Application for a non-material amendment following a grant of planning permission.

Demolition of existing buildings & redevelopment to provide a mixed-use scheme comprising commercial floorspace (B1 use), flexible commercial & community floorspace (B1/D1/D2 use) & residential units (C3 use), together with associated car & cycle parking, plant, supporting facilities, amenity space, landscaping & infrastructure works.

The following section 73 report has been collated to highlight the minor changes to the elevational design, basement and ground floor plans and landscape proposals following the planning approval in October 2020 (2020/00917).

Project:	Hove Gardens	Job No:	33031
Title:	PROPOSED SOUTH ELEVATION		
Scale:	1 : 200 @ A1	Drawn By:	ACK
Date:	JULY 2020	Checked by:	TR
Drawing No:	(20) 201	Revision	P.04

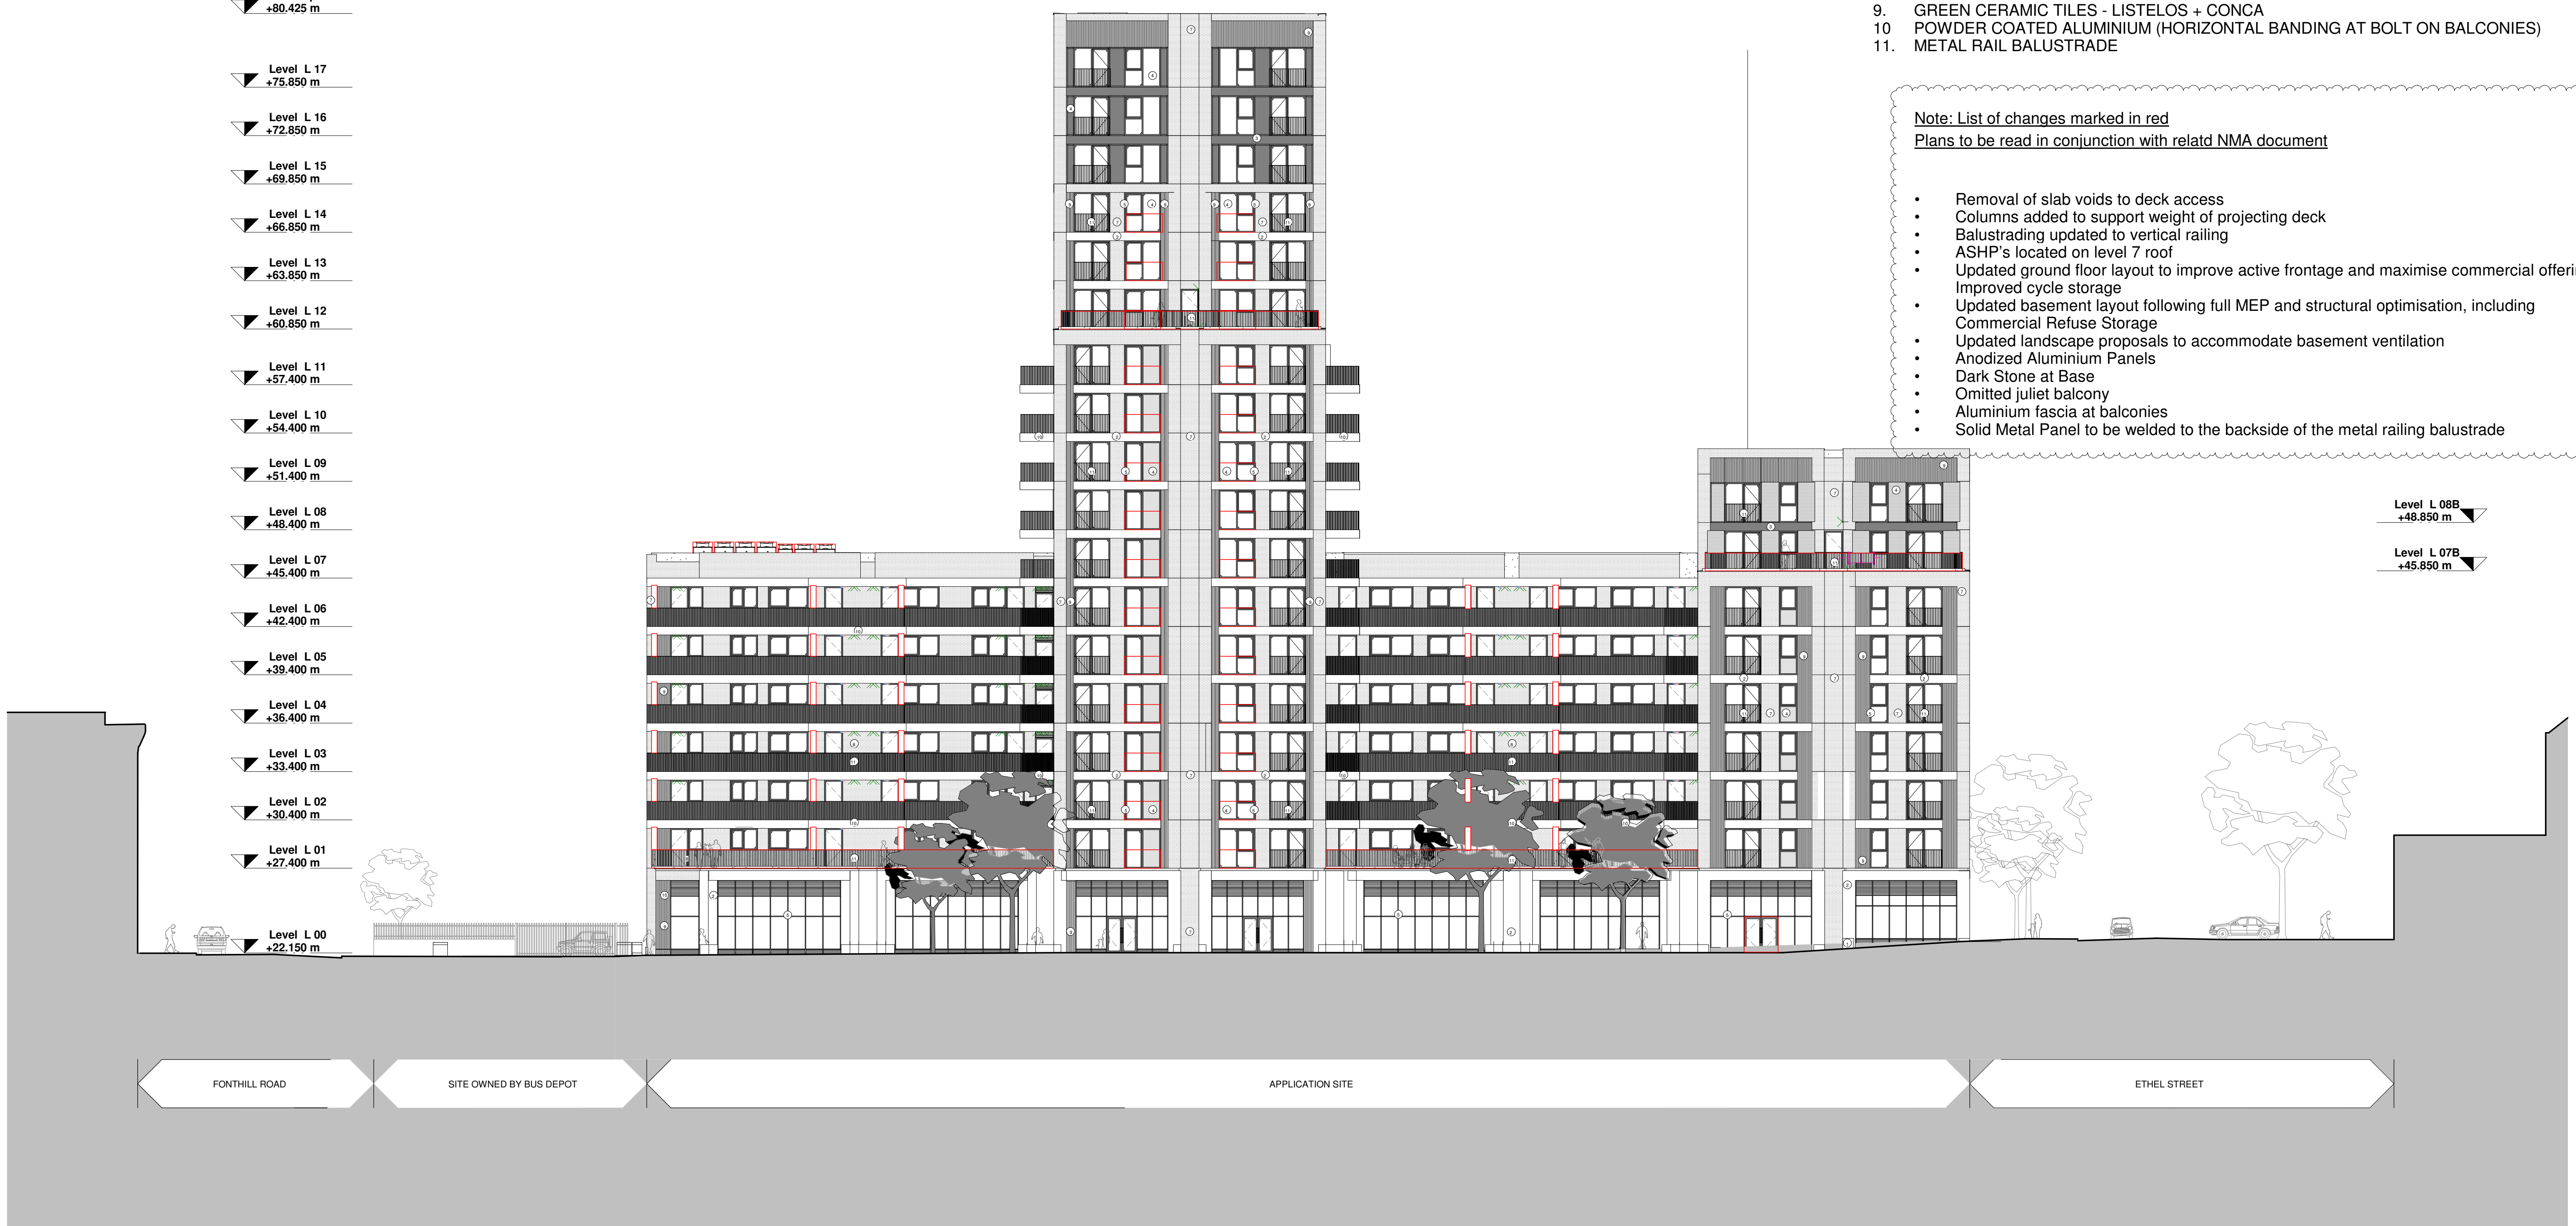
33031-CJCT-A-(20)_099 - P03
33031-CJCT-A-(20)_100 - P03
33031-CJCT-A-(20)_201 - P03
33031-CJCT-A-(20)_202 - P03
33031-CJCT-A-(20)_203 - P03
33031-CJCT-A-(20)_204 - P03

33031-CJCT-A-(20)_099 - P04
33031-CJCT-A-(20)_100 - P04
33031-CJCT-A-(20)_201 - P04
33031-CJCT-A-(20)_202 - P04
33031-CJCT-A-(20)_203 - P04
33031-CJCT-A-(20)_204 - P04
